Rampion 2 Offshore Wind Farm (Project Reference: EN010117)

Deadline 5 Submission (9 July 2024)

West Sussex County Council (IP Reference 200445228)

1 Overview

Company:	WSP	Rampion 2 Offshore Wind Farm
Drawn By:	BRYCC	Figure 18.12a Oakendene Onshore Substation Viewpoint SA3: PRow 1786, Taintfield Wood (Existing View)
Chk/Aprvd:	RYLOR	
Drawn Date:	03/06/2024	Environmental Statement
Status:	FINAL

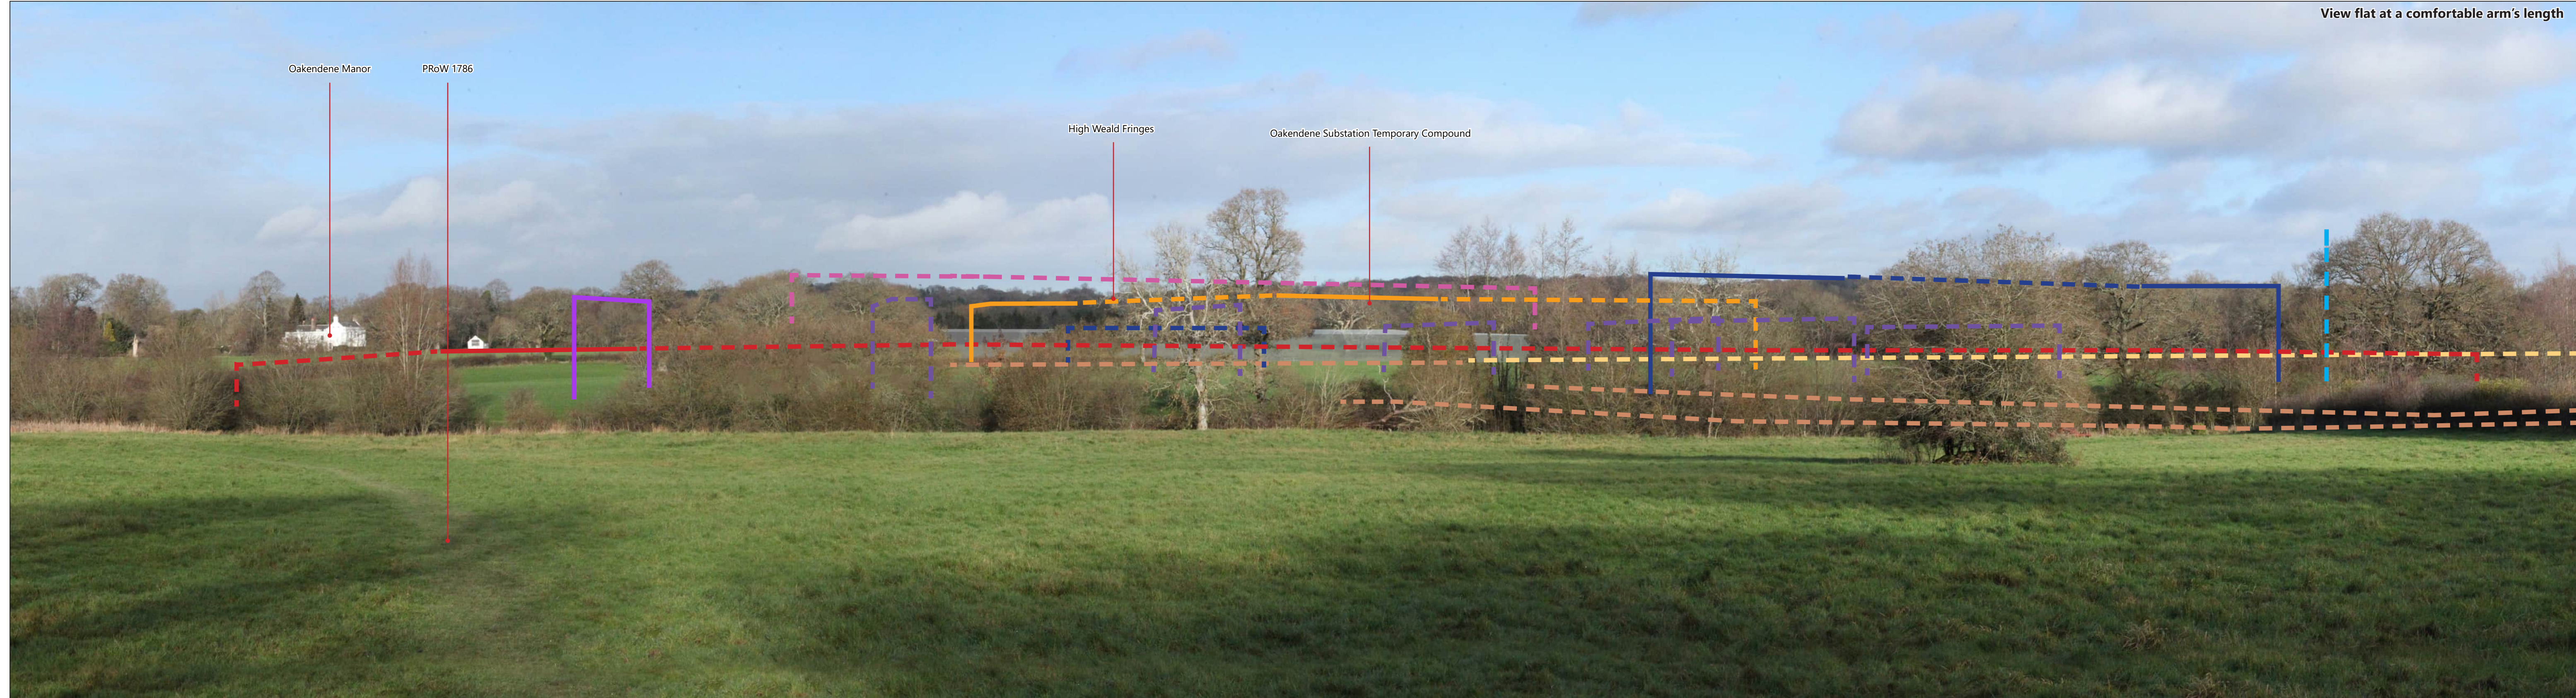
- Figure 18.11b (SA2:A272) does not appear to show vegetation removal that is required at the junction of Kent Street and the A272 (as highlighted in the Outline Construction Traffic Management Plan [REP4-046] – Appendix D, Kent Street Drawings). As such this visualisation may underrepresent potential impacts.
